DEVELOPMENT REVIEW BOARD  
SUPPLEMENTAL SUBMITTAL

PROJECT NO. PR 2019.002651  
Application No. SD 2022.00094

# PLAT OF PARCELS 2A1 AND 2A2 SUNPORT PARK SUBDIVISION (REPLAT OF PARCEL 2A, SUNPORT PARK) SECTION 33, T. 10N., R. 3E., N.M.P.M.

**PLAT OF PARCELS 2A1 AND 2A2
SUNPORT PARK SUBDIVISION
(REPLAT OF PARCEL 2A, SUNPORT PARK)
SECTION 33, T.10N., R.3E., N.M.P.M.
ALBUQUERQUE, BERNALILLO COUNTY, NEW MEXICO
JUNE 2022**

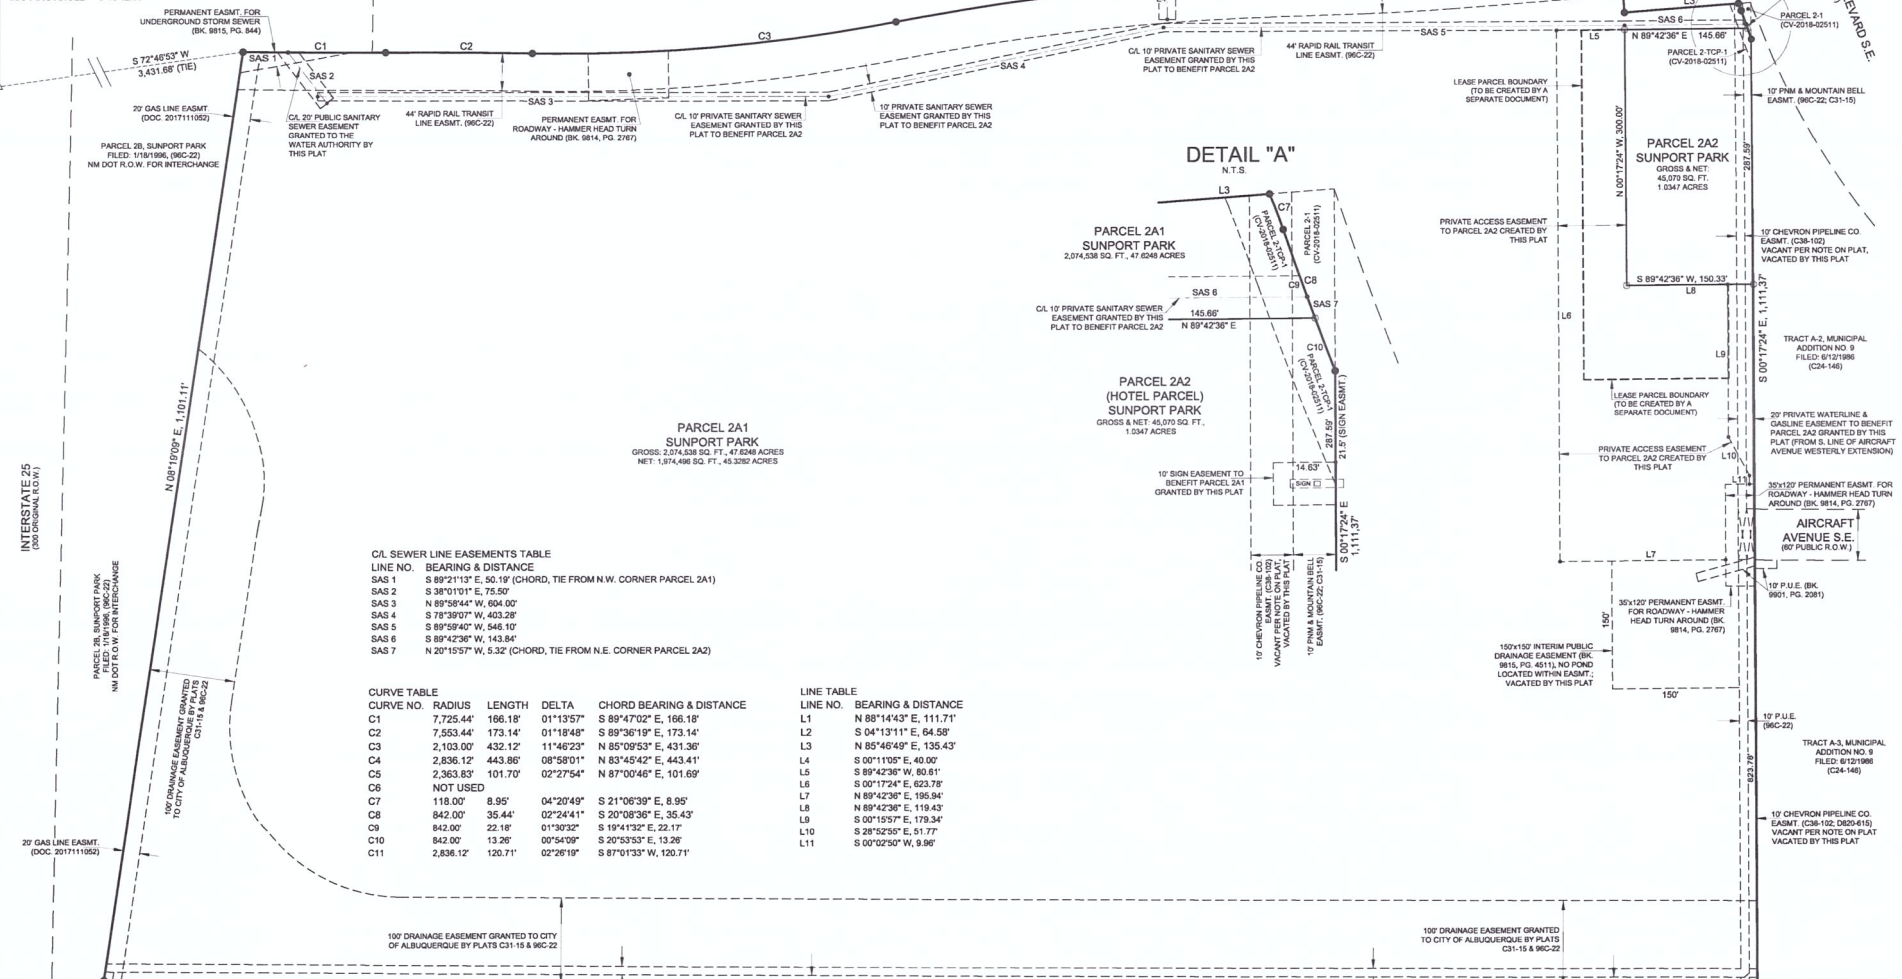
1) ADD 'GRANTED TO WATER AUTHORITY' FOR PROPOSED PUBLIC SANITARY

SEWER EASEMENT AT NW CORNER OF SUBJECT PROPERTY

2) REMOVE 'TO BE VACATED BY THIS PLAT' FOR RAPID RAIL TRANSIT LINE EASEMENT
